CITY OF ALBUQUERQUE

December 23, 2021

Re: Congress Apartments
9441 Eagle Ranch Rd. NW
Traffic Circulation Layout
Architect's Stamp 09-28-21 (C13-D033)

Dear Mr. McEachern,
Based upon the information provided in your submittal received 10-25-21, the above referenced plan cannot be approved for Building Permit until the following comments are addressed:

REVISION DATE

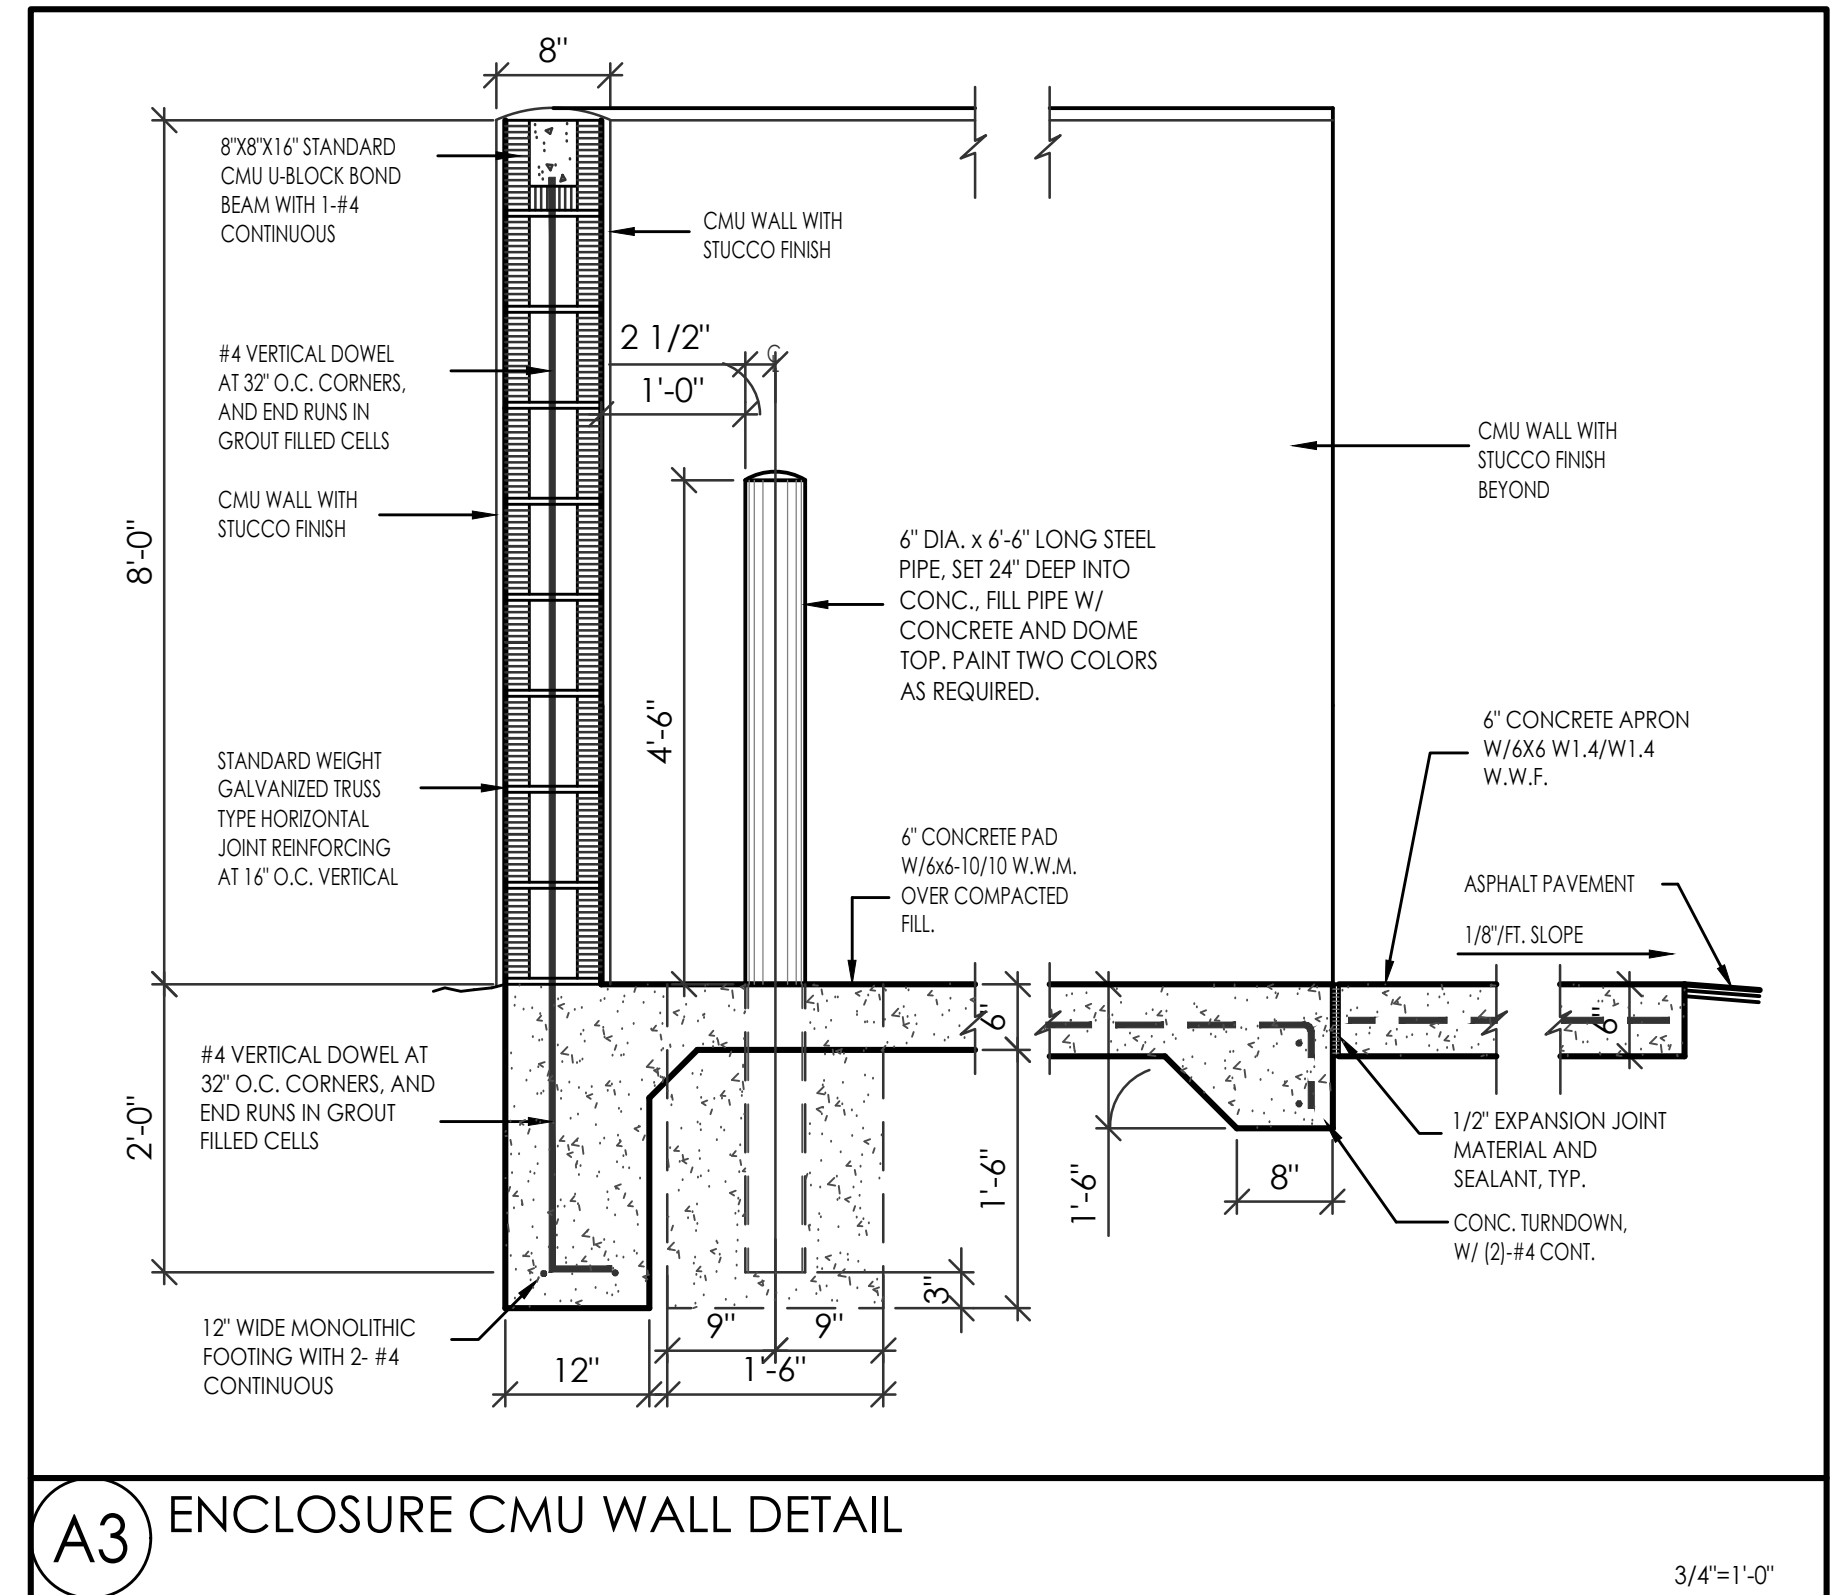
1. Provide a multi-directional ramp at the west leg of the drive entrance off Eagle Ranch Rd. where interior sidewalk connection is to be provided. Call out details.
2. Provide details for the Ramps in front of the Dumpster Enclosure.
3. Key note 20: provide dimensions for the clear sight triangle.
4. ADA aisle between building A and B should be 8.5 ft. wide.
5. The width for the Parallel Parking should minimum 7 ft.
6. Details sheet: Accessible Ramp (A10): The running slope should be 1:12 maximum. Please revise accessible ramp details.

1. Added ROW, Medians, curb cuts and street widths. See new revised AS-1.0 Site Plan sheet.
2. Added new hatch to show 6' wide ADA accessible pedestrian pathway

3. Added new 6' sidewalk at all parking stalls.
4. Removed and replaced detail A-10 on sheet AS-2.0.
5. Added detail for Handicap symbol.
6. Yes, please see detail on sheet on AS-2.0

7. Removed COA standard
8. Labeled all Fire lanes
9. See new detail A12/AS-2.0
10. Update COA standard drawings to 2426
11. Removed work order note. It was copied from a previous note.

12. Removed note. Will only remove fence on our property.
13. Removed Key note 33. It was a typo.
14. Added to key note 34 per TCL review.
15. Added ramps and COA standard drawings #2445.

16. See resubmitted Site plan.
17. The lengths were on the plan in the Curve Table at the top of the page, added the lengths to the plans at per TCL review.

18. Added dimensions to curb cuts.
19. Added new ramp details on sheet AS-2.0 and note to keynotes to reflect detail.
20. Please see attached email between owner and adjacent owner.

21. Added curb barrier to parking spaces as needed.
22. Extended Island ramp, see revised site plan
23. Add note for all bollards to be painted yellow/
24. Updated detail to reflect TCL Review.
